From: Jonathan Best <Jonathan.Best@arun.gov.uk>
Sent: 26 September 2025 09:43
To: Planning.Responses <Planning.Responses@arun.gov.uk>
Cc: Harry Chalk <Harry.Chalk@arun.gov.uk>
Subject: A/142/25/DOC

Wilmington Arundel Road Angmering BN16 4ET.

I have reviewed the approval of details reserved by condition imposed under A/44/24/PL relating to condition 3 - Biodiversity Enhancement Layout.

Project	Gatehouse, Angmering	Date	Oct 2025	Drawing No.	CSA/6521/102
Drawing Title	Ecological Enhancements Plan	Scale	Refer to scale	Rev	A
Client	JW Stratton	Drawn	JR	Checked	JR

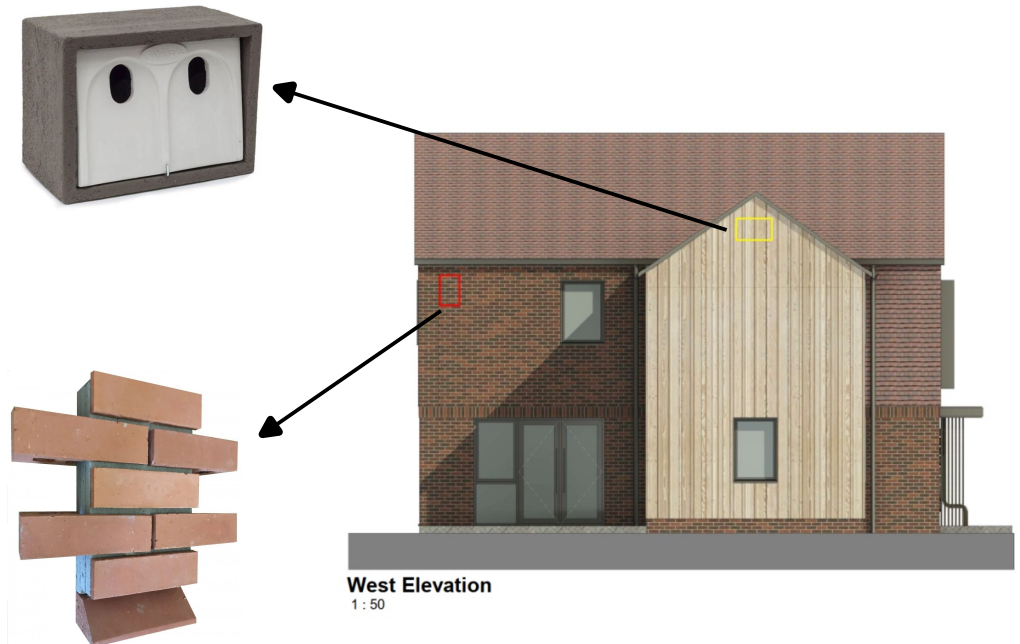
The Biodiversity enhancement layout has one sparrow terrace identified. None of the other ecological enhancements set out in the Preliminary Ecological Appraisal CSE/6521/01 (May 2023) have been included. These are listed below.

The condition wording below calls for providing the finalised details and locations of the enhancement measures.

Based on the information provided I cannot recommend discharge of this condition at this time.
